Re: Request for Council's Advice on EIS – SSD-70316465

Liverpool City Council was invited to provide input into the EIS for Burrah Park.

Attachment A – Detailed comments

Figure 8: Sydney Water proposed regional basins

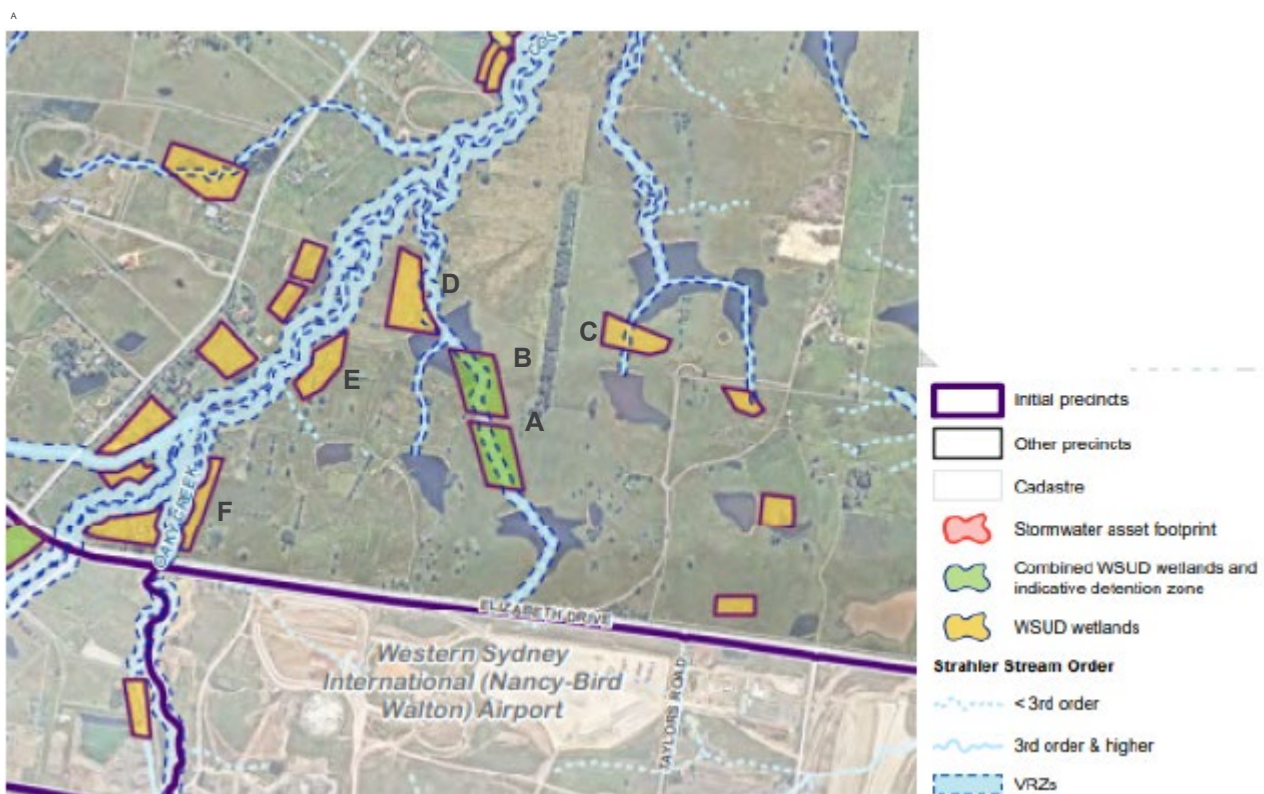
Regional stormwater basins must satisfy the 15 hectare catchment requirements under the DCP and it must be demonstrated that regional catchments are being managed by the regional stormwater authority. The design of the proposal must not redirect regional flows into Council's local (road reserve) assets and ideally pre and post development catchments should be generally identical.

- b- Sydney Water, acting as the Regional Stormwater Authority for the Western Sydney Aerotropolis Precinct, plans to establish a network of regional water quality basins within the precinct. However, the proposed development has encroached significantly on land designated for future stormwater infrastructure. According to the masterplan, this development will substantially reduce the size of the regional basins, potentially hindering the achievement of water quality targets for both current and future developments within the Liverpool LGA. All developments in the Western Sydney Aerotropolis Precinct must align with the regional basin delivery plan, and the proposal must be amended accordingly. It is recommended that the applicant liaise with Sydney Water to address these concerns.
